Subject: RE: White Cottage (WA/22/19/PL)

Drawing B16b August 2018 Scale 1:20 & 1:100 @ A1
Building Regulation Drawing - Externals Plan

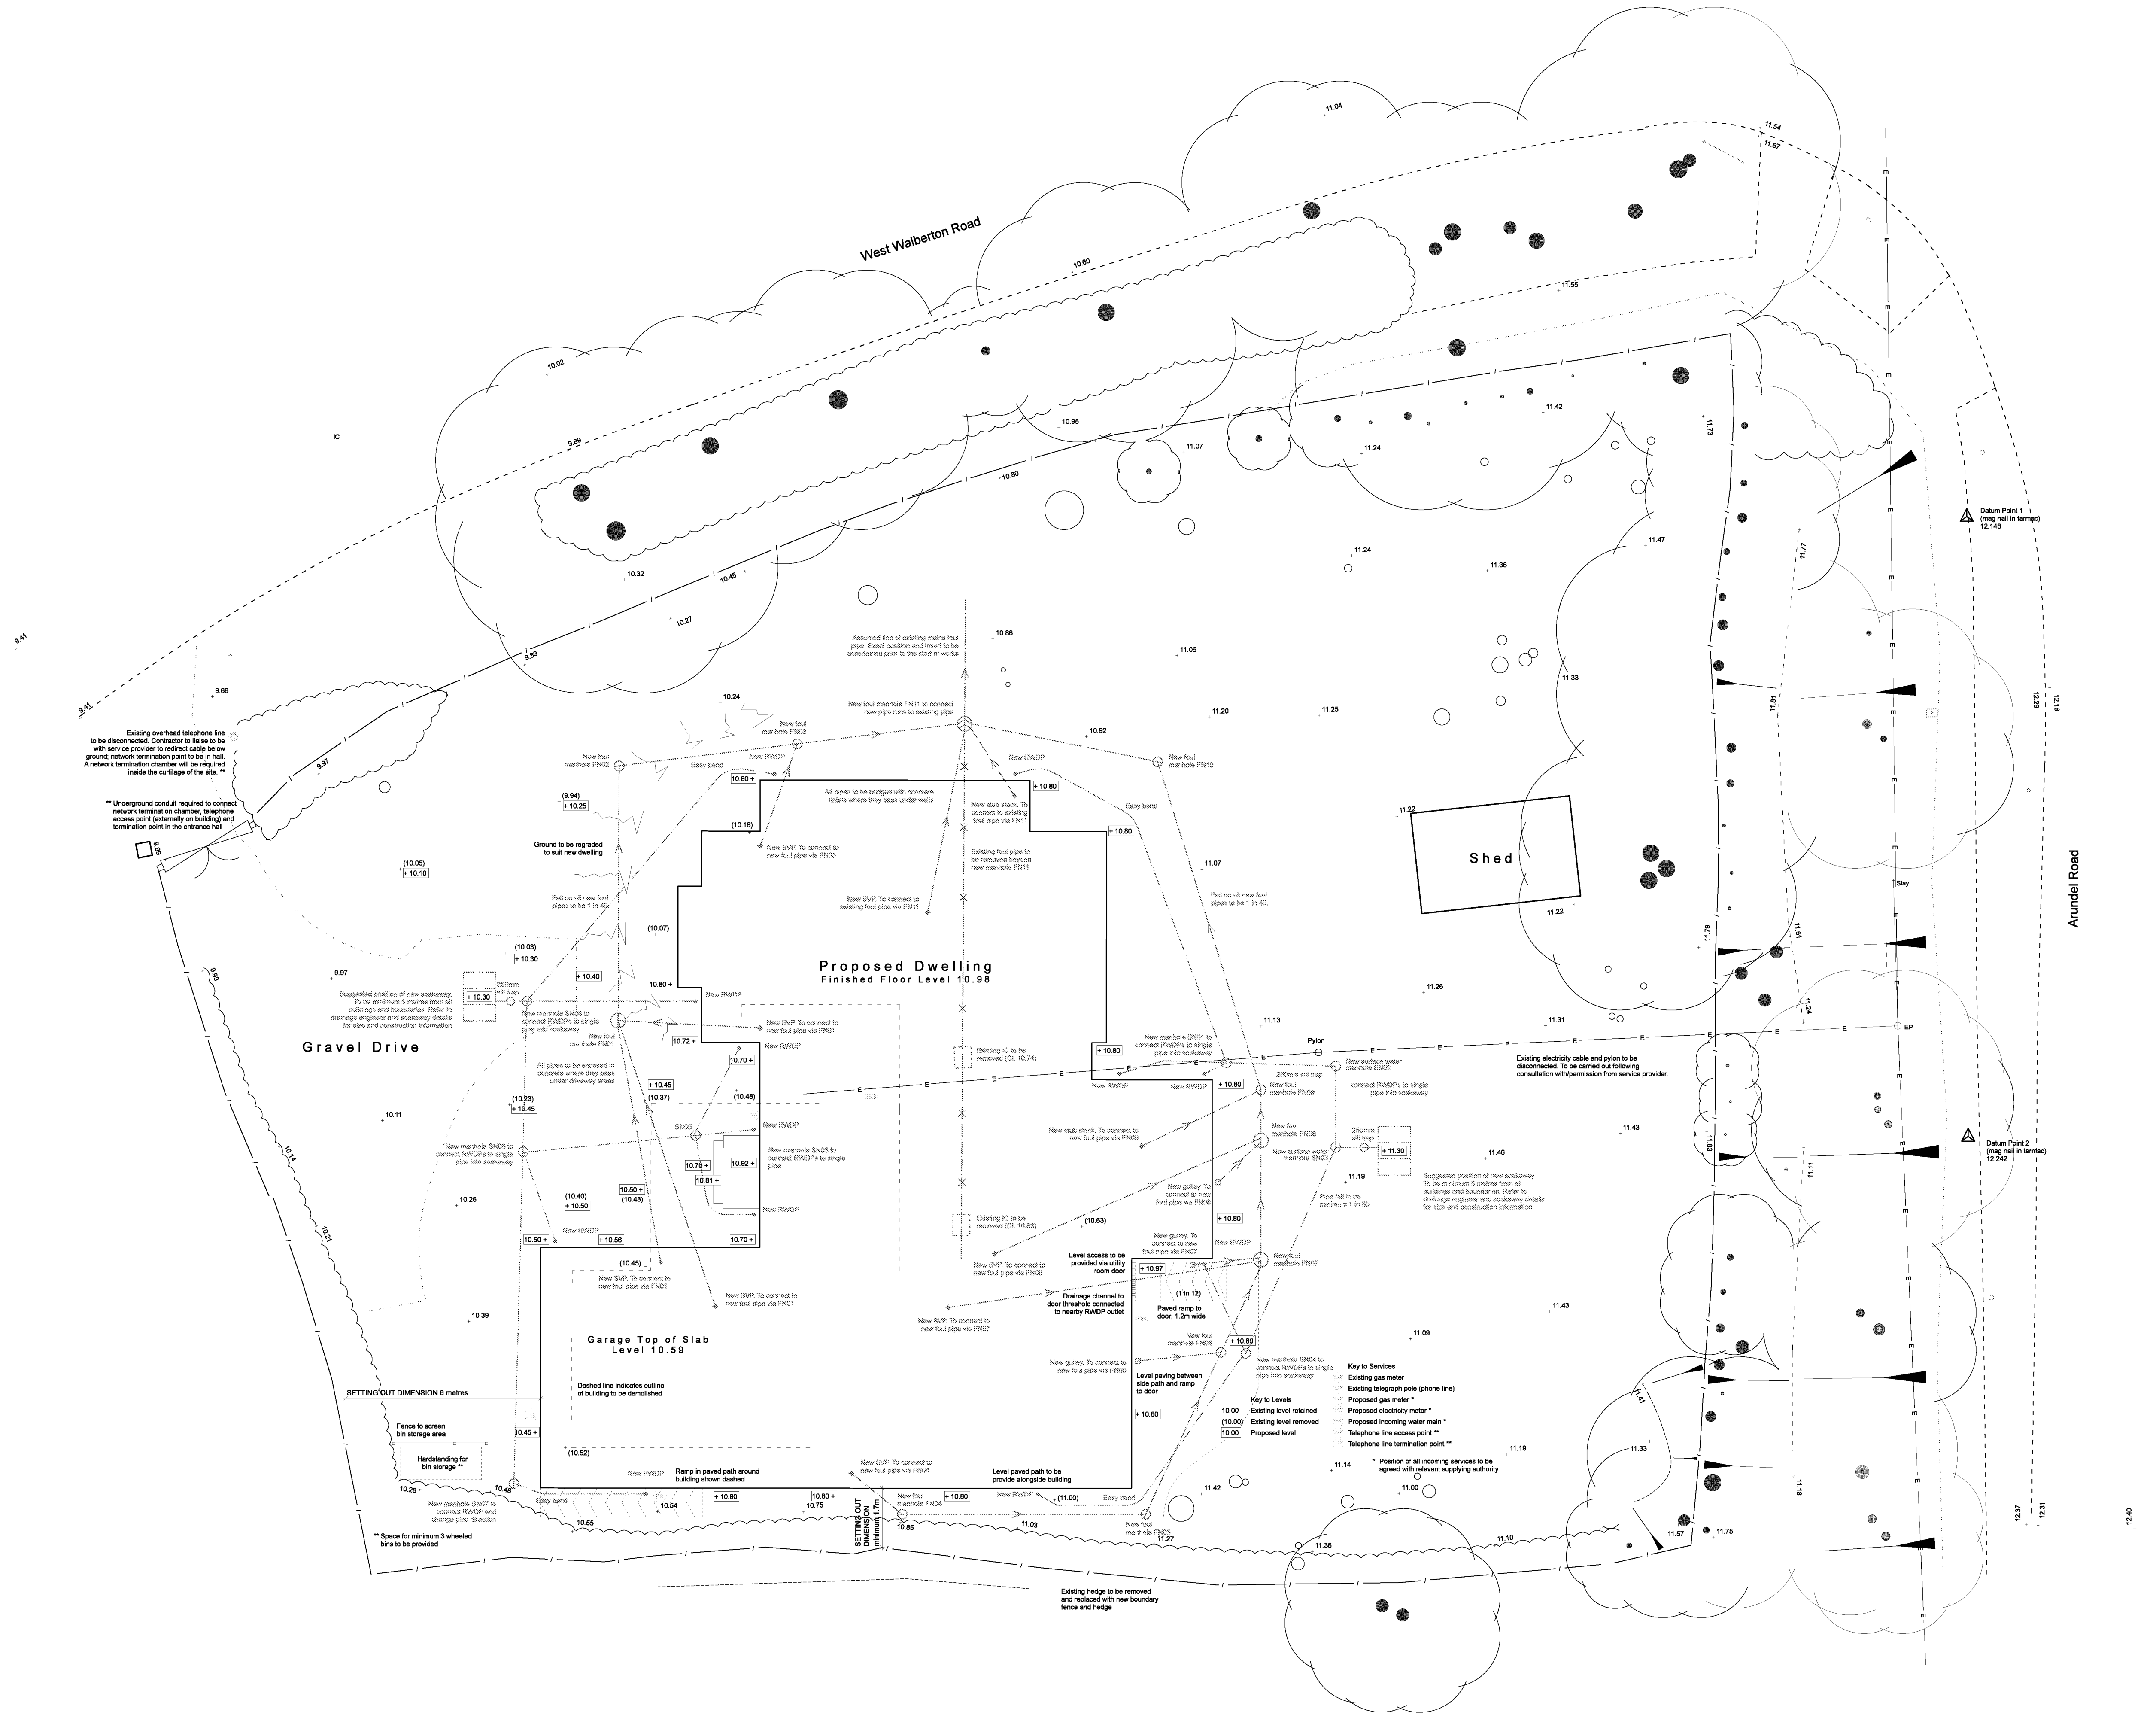
I have had a look through this this morning and I am not sure that the agent/engineer has understood Laura's comments. The sizing of the soakaways have reduced rather than increased, they have instead proposed to infiltrate through the base of the soakaways which we discourage. They have at least proposed silt traps. The calculation used to estimate outflow appears to be a manipulation of BRE365/DG265 to account for the base. This is not appropriate, if the base is to be used then CIRIA 156 calculations will need to be applied. (See the recommended DG265 calculation for outflow below as compared with what has been submitted.)

As a result of their calculations the required storage capacity of the soakaways has decreased rather than increased. Using our own models the proposed solution fails on a number of storm durations.

On the basis of Laura's comments I am not going to scrutinise the plans any further. I am happy that the inspection chambers have been included and that the plans now include pipe diameters and falls.

Following the recent comments from Laura Gibbons, a safety factor of 3 has been allowed; this is achieved by the use of silt traps and considering discharge through the base of the soakaways. In addition, easy bend have been replace with inspection chambers and pipe diameters and falls added.
